**DELEGATED DECISION FOR APPLICATION FOR CERTIFICATE OF
LAWFUL DEVELOPMENT**

Reference no.: 2024/CL/91321/E

Site: Overbrook, 24, Arkenley Lane, Almondbury,
Huddersfield, HD4 6SQ

Description: Certificate of lawfulness for proposed single storey
side extension and rear dormers

client	MR & MRS BECKETT		
project	PROPOSED EXTENSION 24 ARKENLEY LANE ALMONDBURY HUDDERSFIELD HD4 6SQ		
drawing	EXISTING PLANS AND ELEVATIONS		
revision	notes	date	drawn
1			
scale :	1:100 AT A1	02.24	MG
project no.	drawing no.	revision	
2334	01

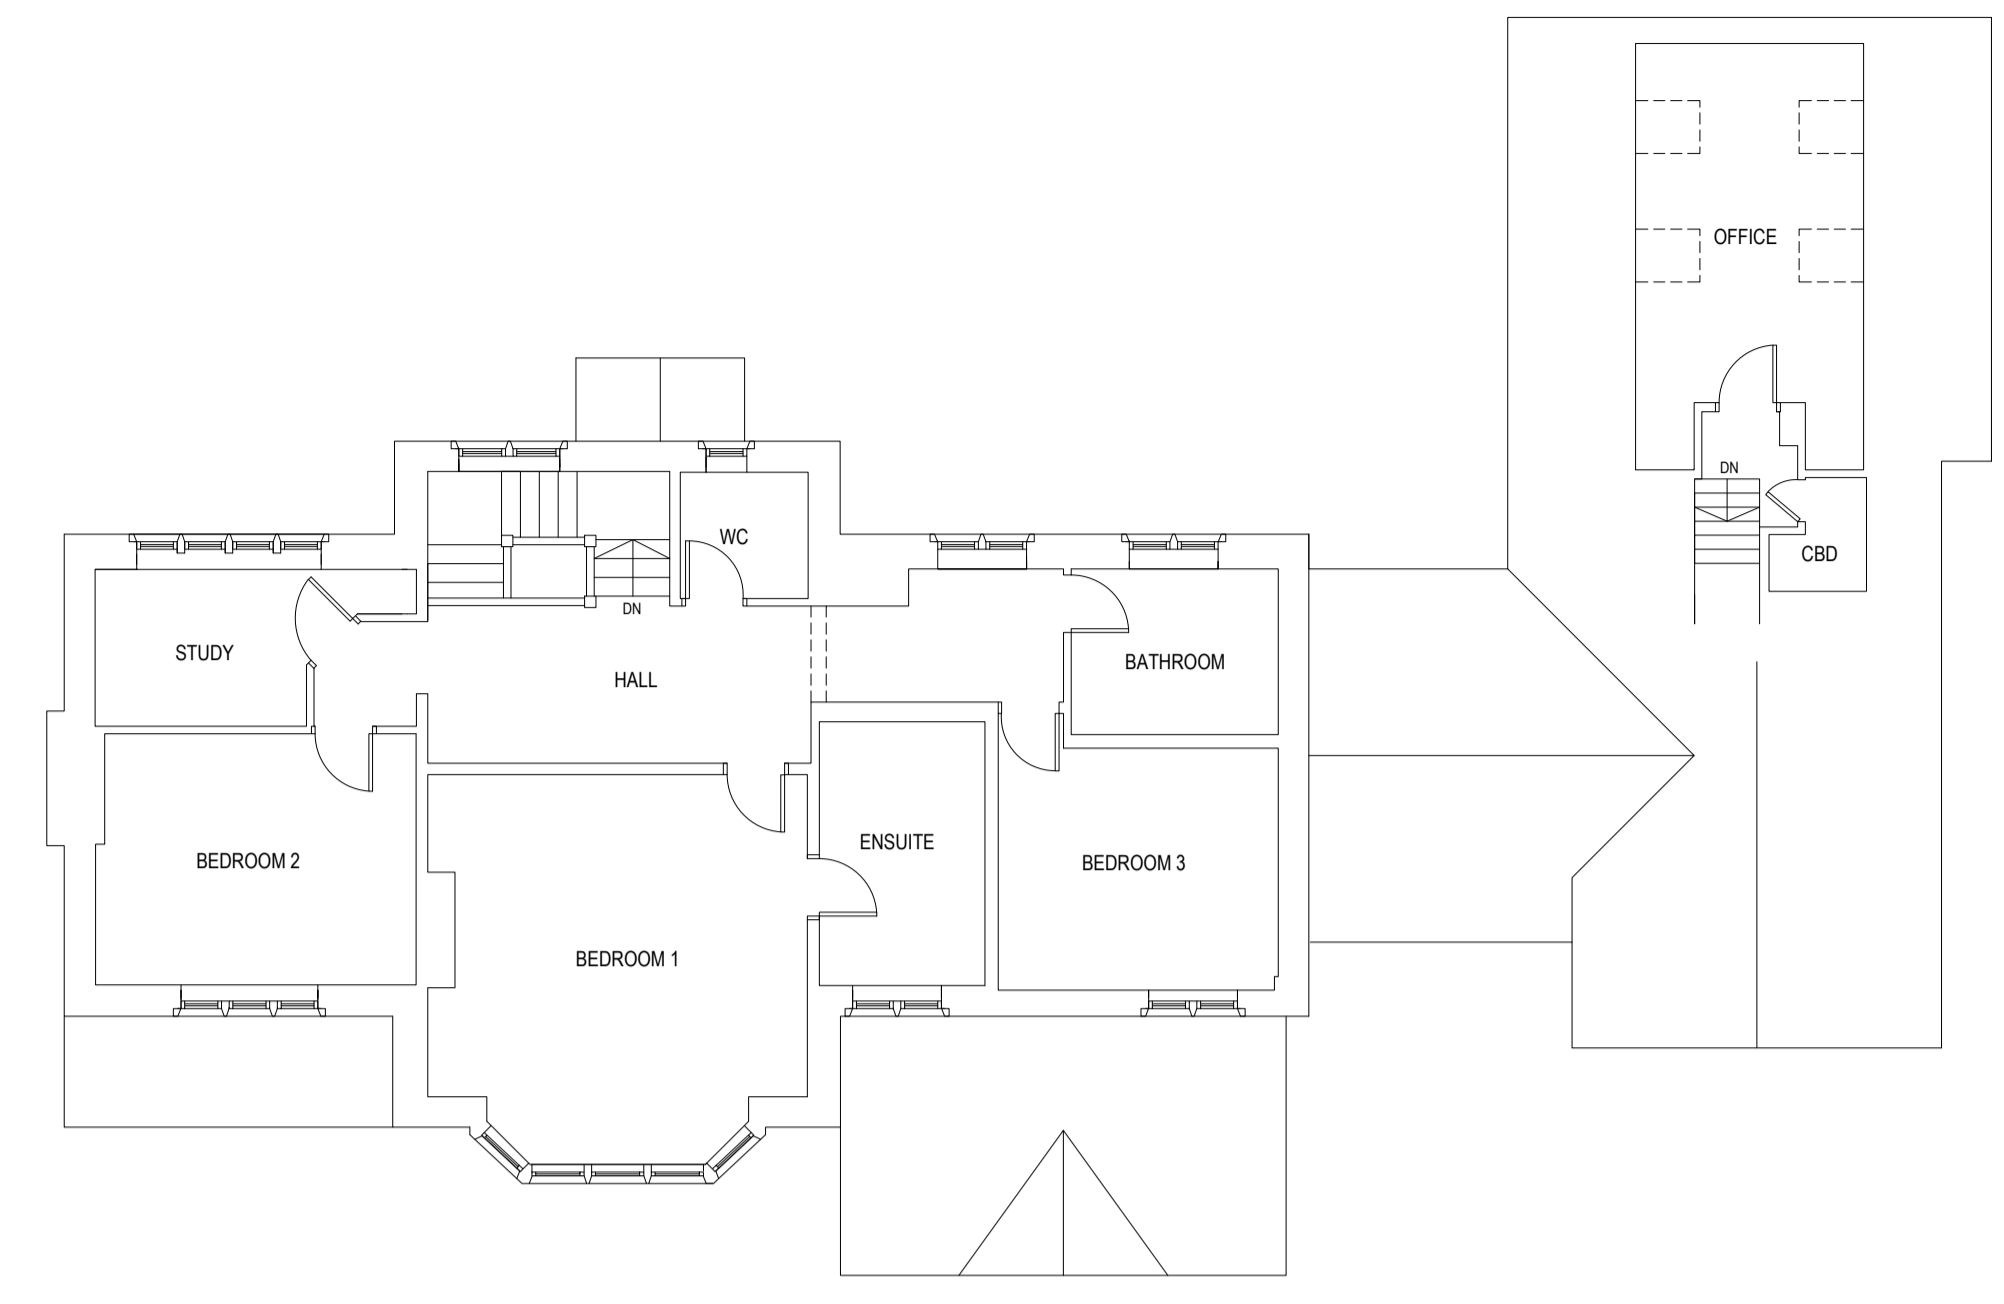
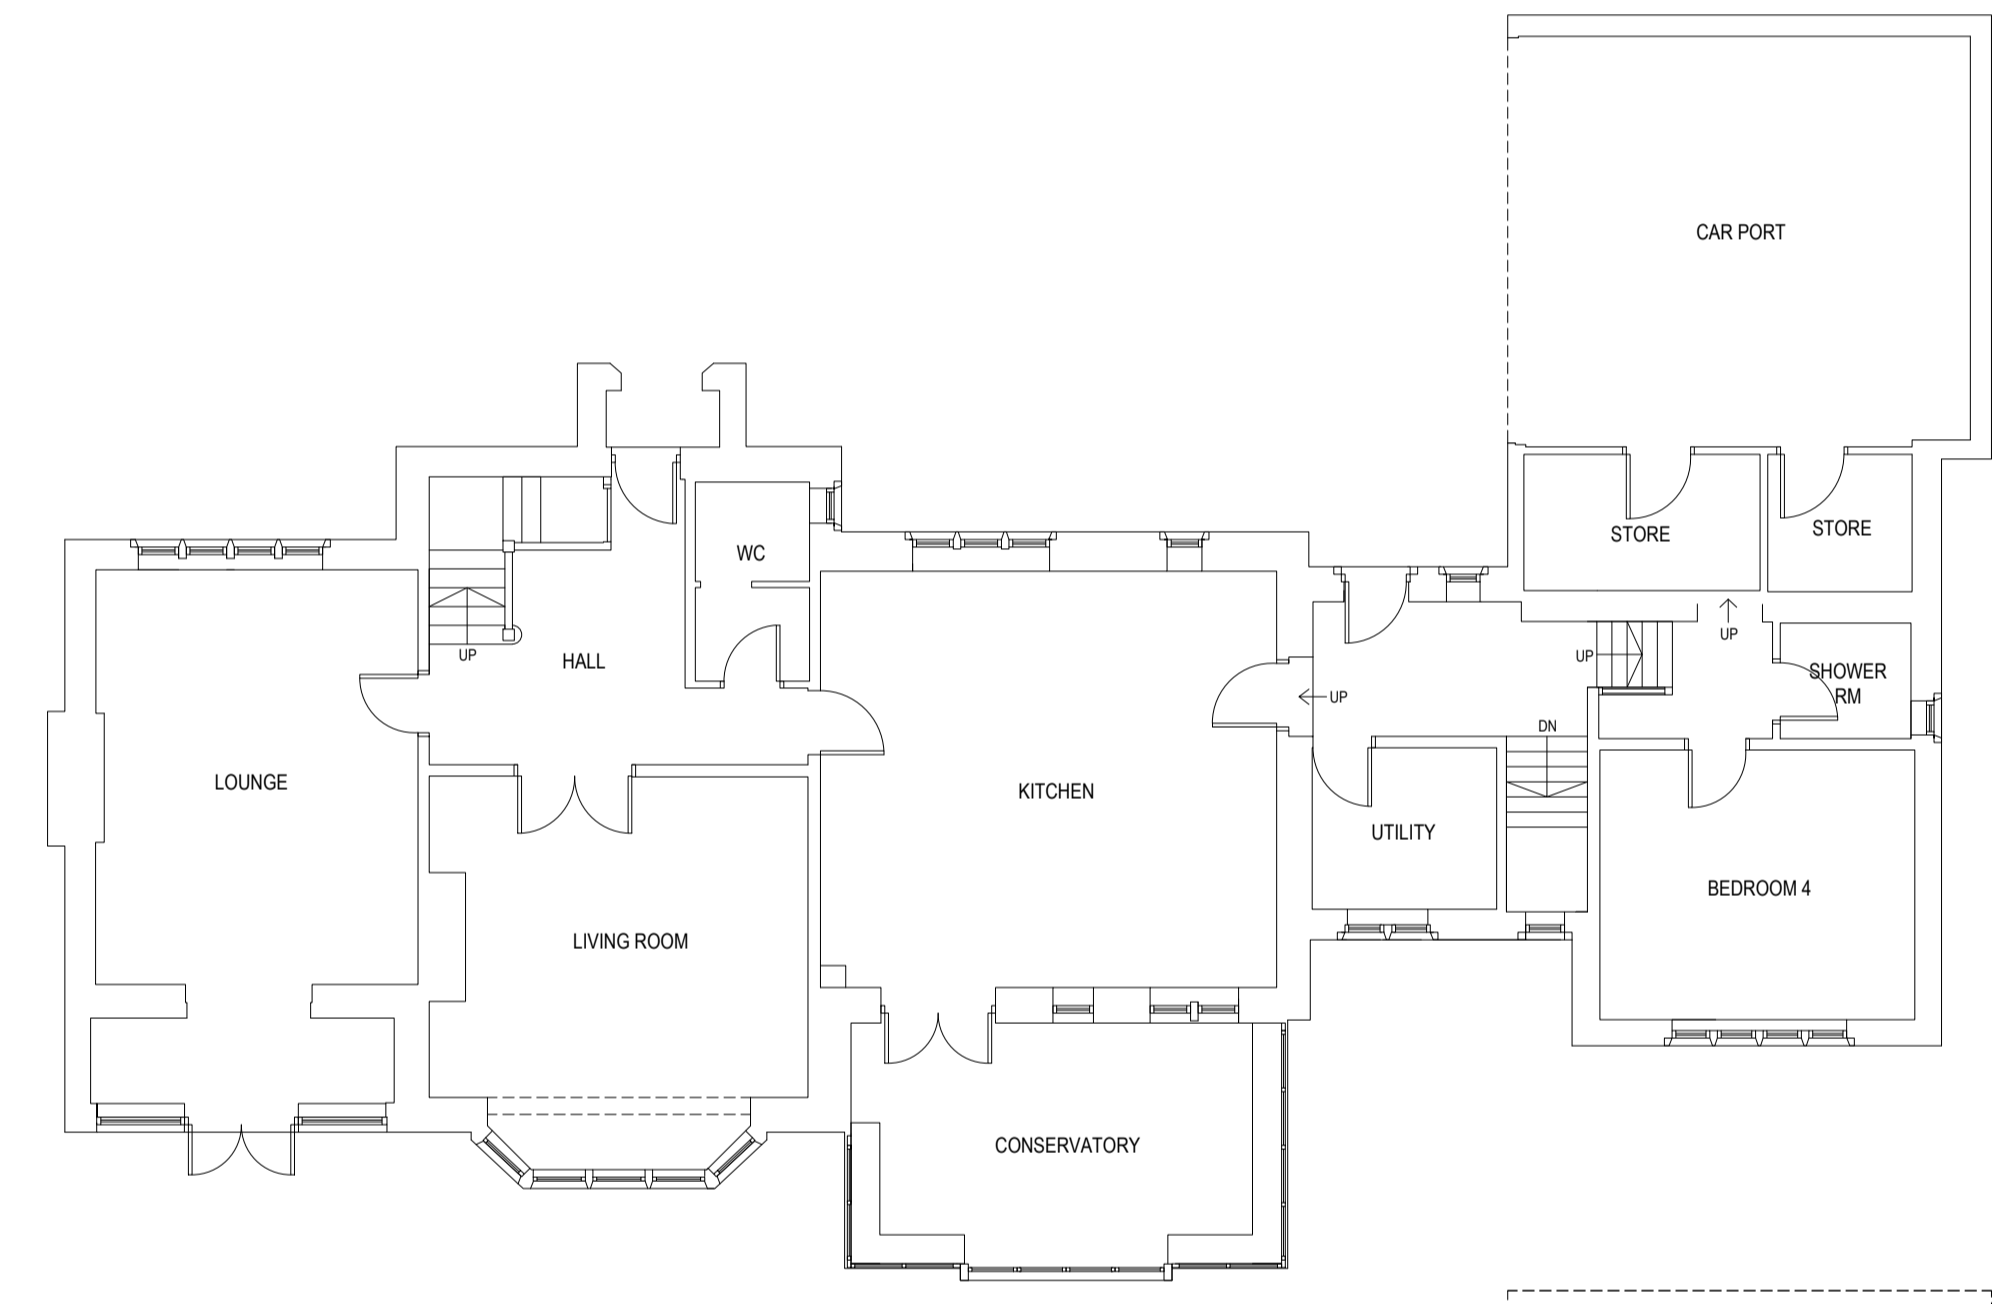
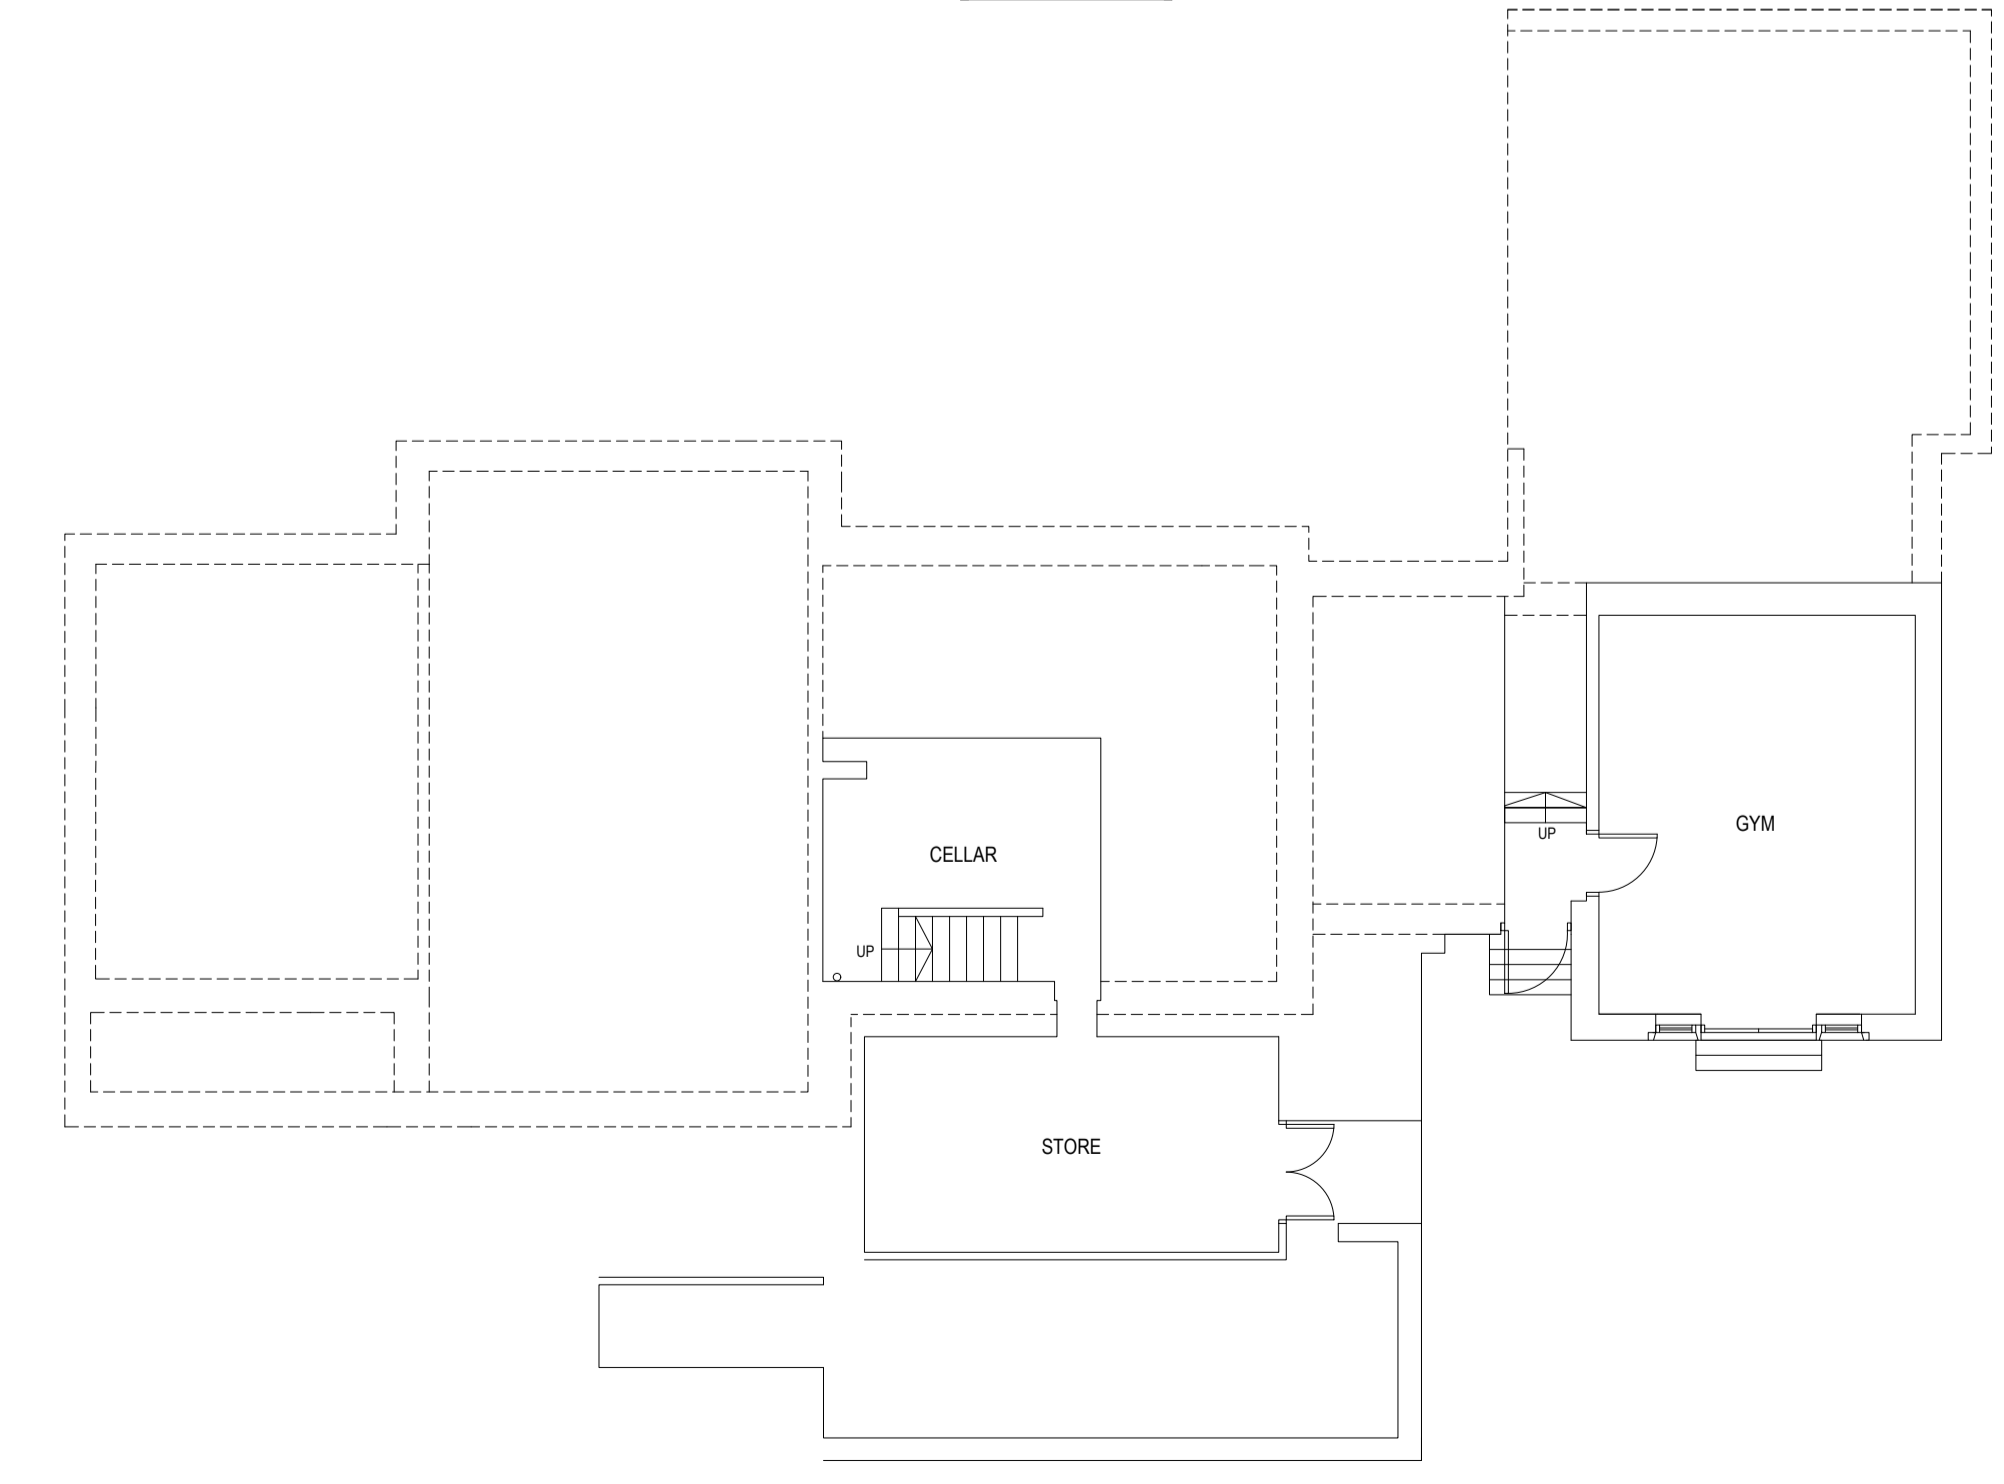
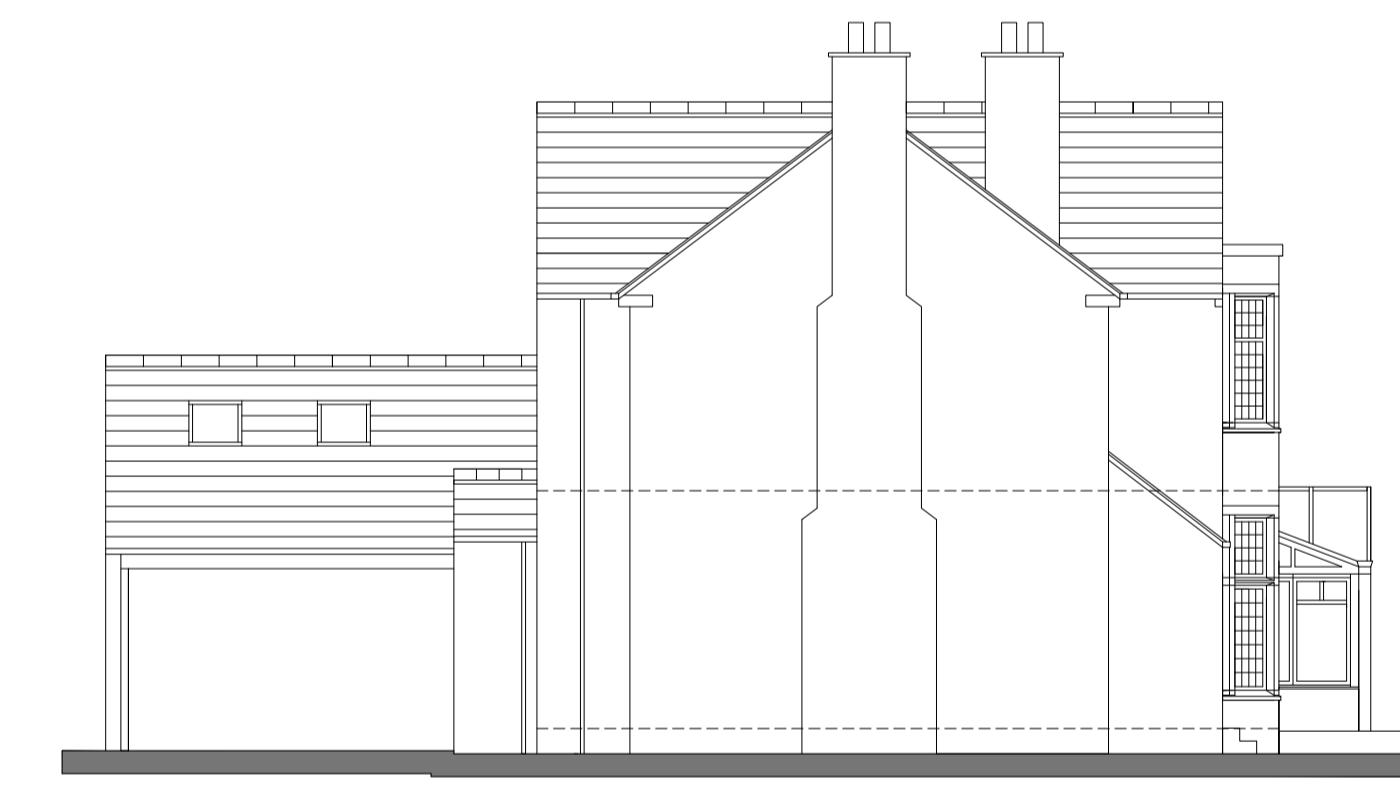
I calculated a different measurement for the total cubic metres of the proposed rear dormers. I calculated the total cubic metres as, 29.1m³; in the supporting statement the agent advises the total as 26m³. In negotiations, I contacted the agent to query this, they then recalculated the measurement as 28m³. This is a small discrepancy and does not impact the lawfulness of the development.

Left rear dormer (as proposed): 10.3 m³

Right rear dormer (as proposed): 18.8 m³

Total: 29.1 m³ - these calculations have been taken from measuring the plans to scale. My total calculation differs from the agent's [listed in the supporting statement as 26 m³], however, both are within the criteria/less than 50 cubic metres.

Comment: *The eaves of the original roof would be maintained. The proposed dormers would be set back from the existing eaves by 0.2 metres. The*

proposed dormers would also not extend beyond the outside face of the external rear elevation.
